Rezoning Transportation Analysis
Petition Number: Insert Zoning Petition #2020-195
General Location Identifier: Tax ID 21159315

Revision Log:	Date	Description
	01-21-21	First Review (LJ)
	02-15-21	Second Review (LJ)

The site is located on Rea Road (minor thoroughfare, state-maintained), is in the South Wedge outside of Route 4.

JOB # 20043  
 DATE: 11/10/20  
 SCALE: 1" = 30'  
 DRAWN BY: JAW  
 APPROVED BY: JCO  
**RZ-1**

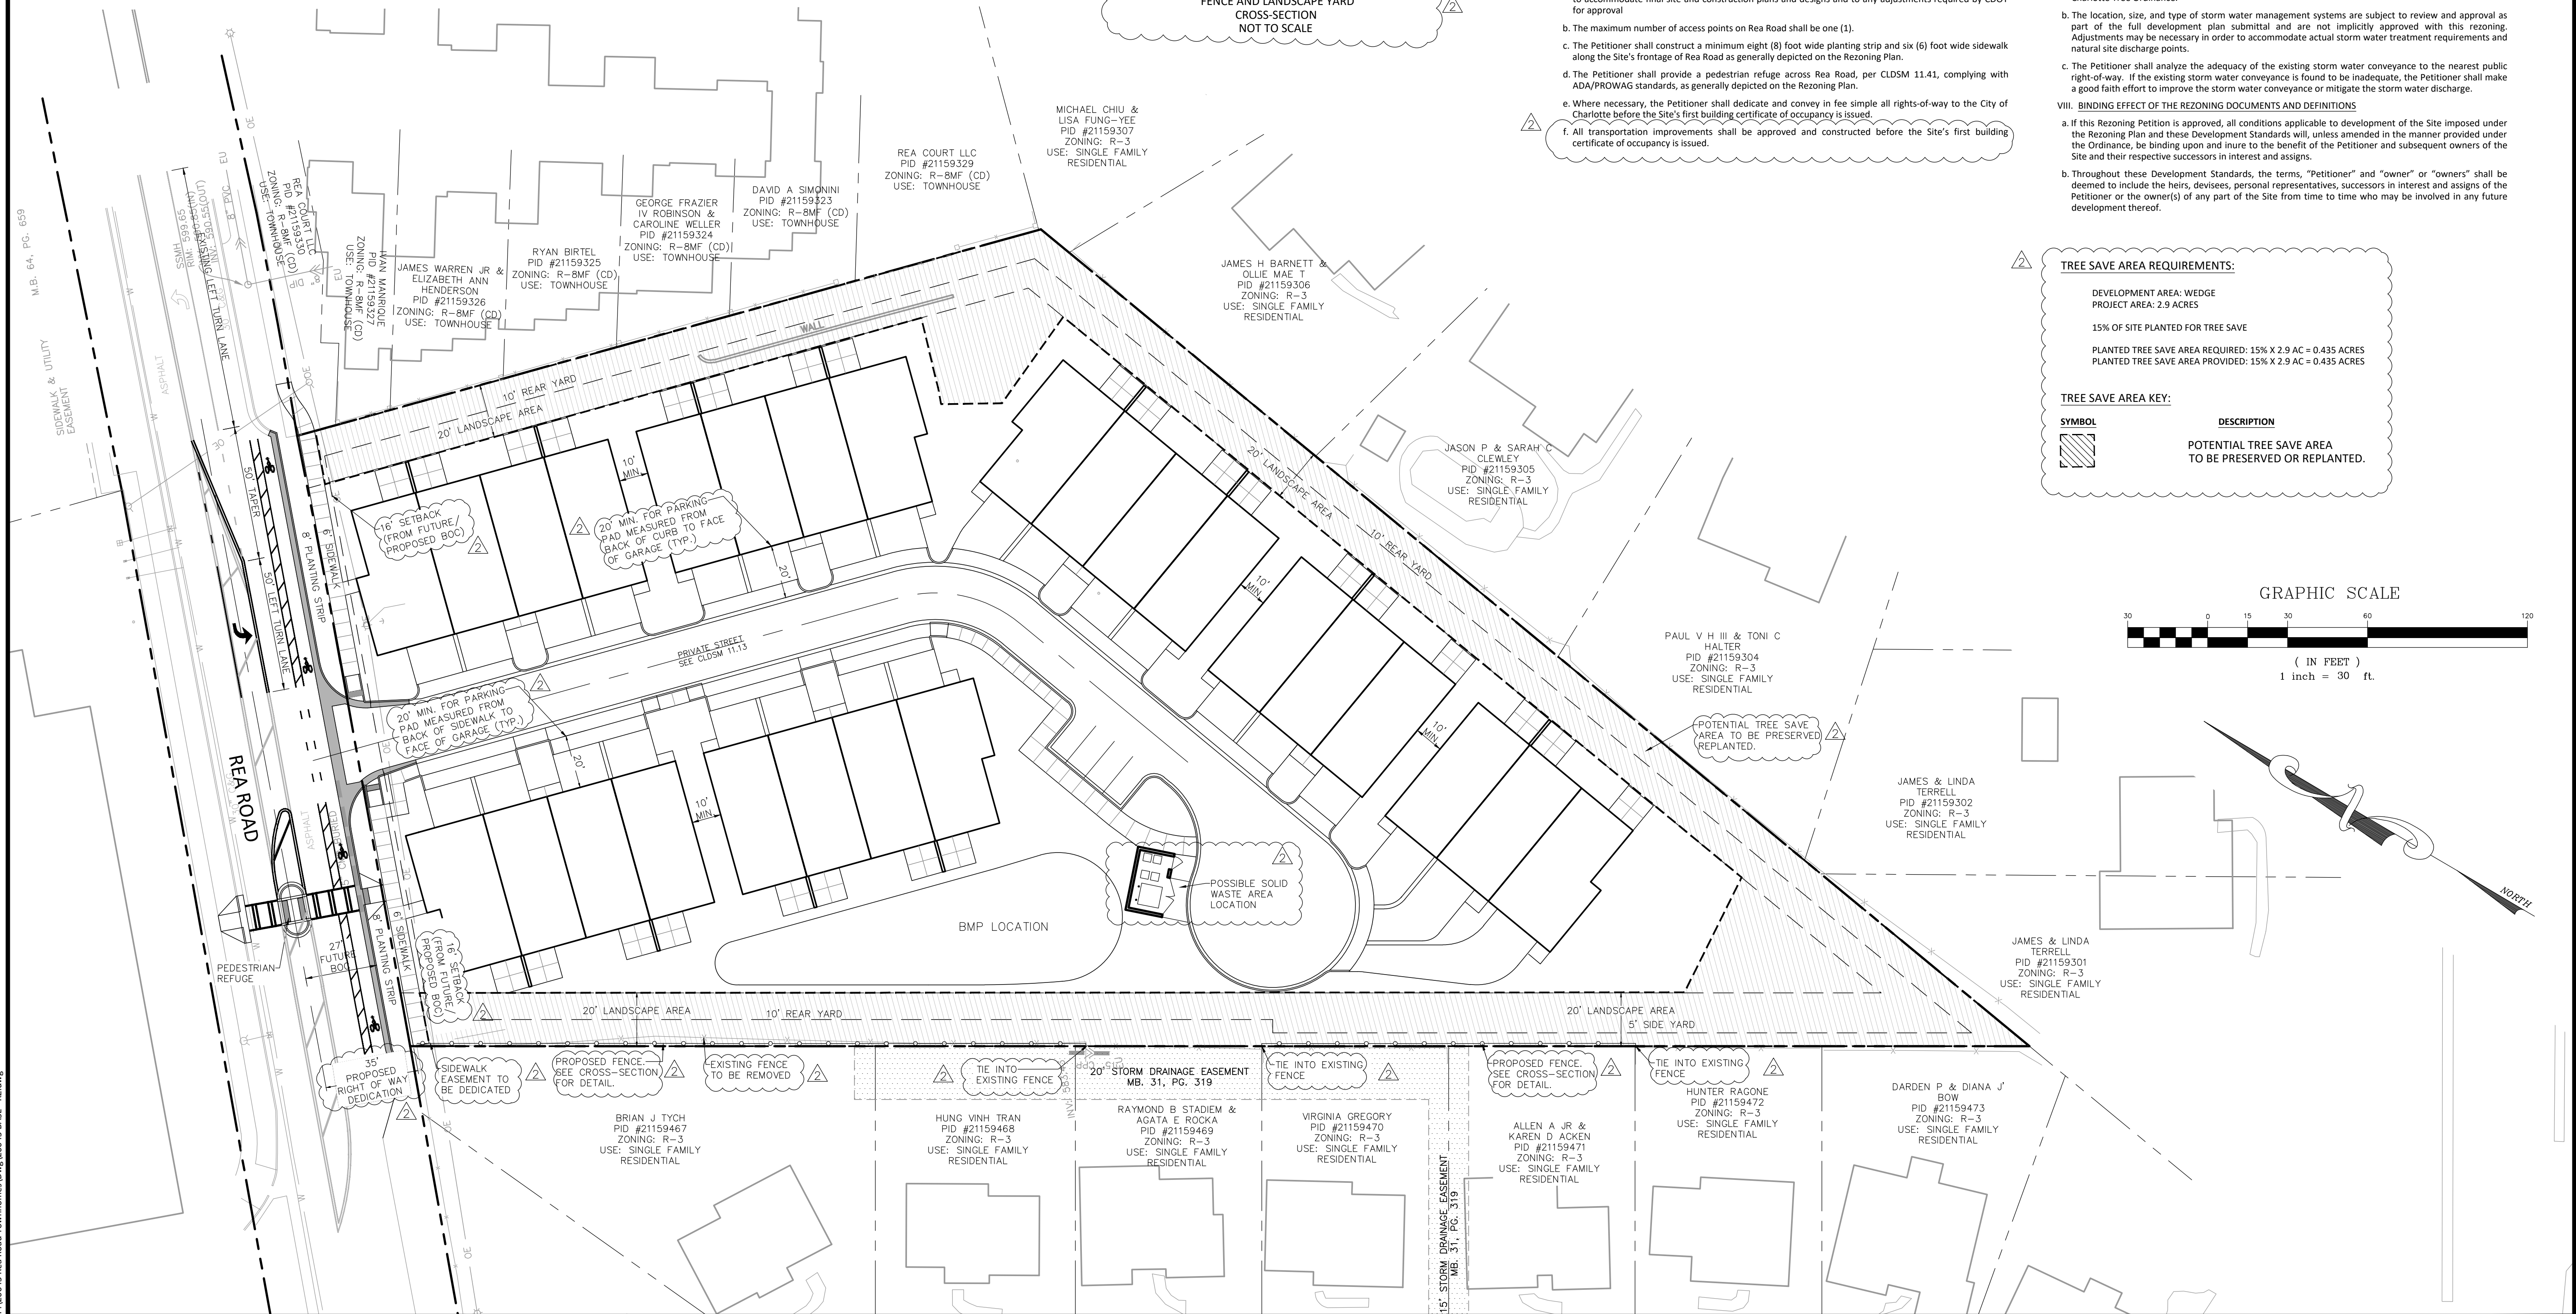
- OUTSTANDING (02/15/21):** Revise site plan and conditional note(s) to commit to dedicate 35' right-of-way from the road centerline. The site plan shall label and dimension the right-of-way from the road centerline per Chapter 20 of the City Code.

- Provide a left turn lane on Rea Road as required by NCDOT. Restripe Rea Road, per NCDOT Roadway Standard Drawing for PAVEMENT MARKINGS Turn Lanes, 1205.05, to accommodate the left turning lane to include storage.

8. **OUTSTANDING (02/15/21):** ~~A site plan note(s) specifying dedication and fee simple conveyance of all rights-of-way to the City before the site's first building certificate of occupancy is issued is needed.~~ CDOT requests rights-of-way set at 2' behind back of sidewalk where feasible.
9. **OUTSTANDING (02/15/21):** A site plan note(s) specifying that all transportation improvements will be approved and constructed before the site's first building certificate of occupancy is issued is needed. The petitioner may phase transportation improvements if said improvements and phasing are explicitly described in site plan notes.
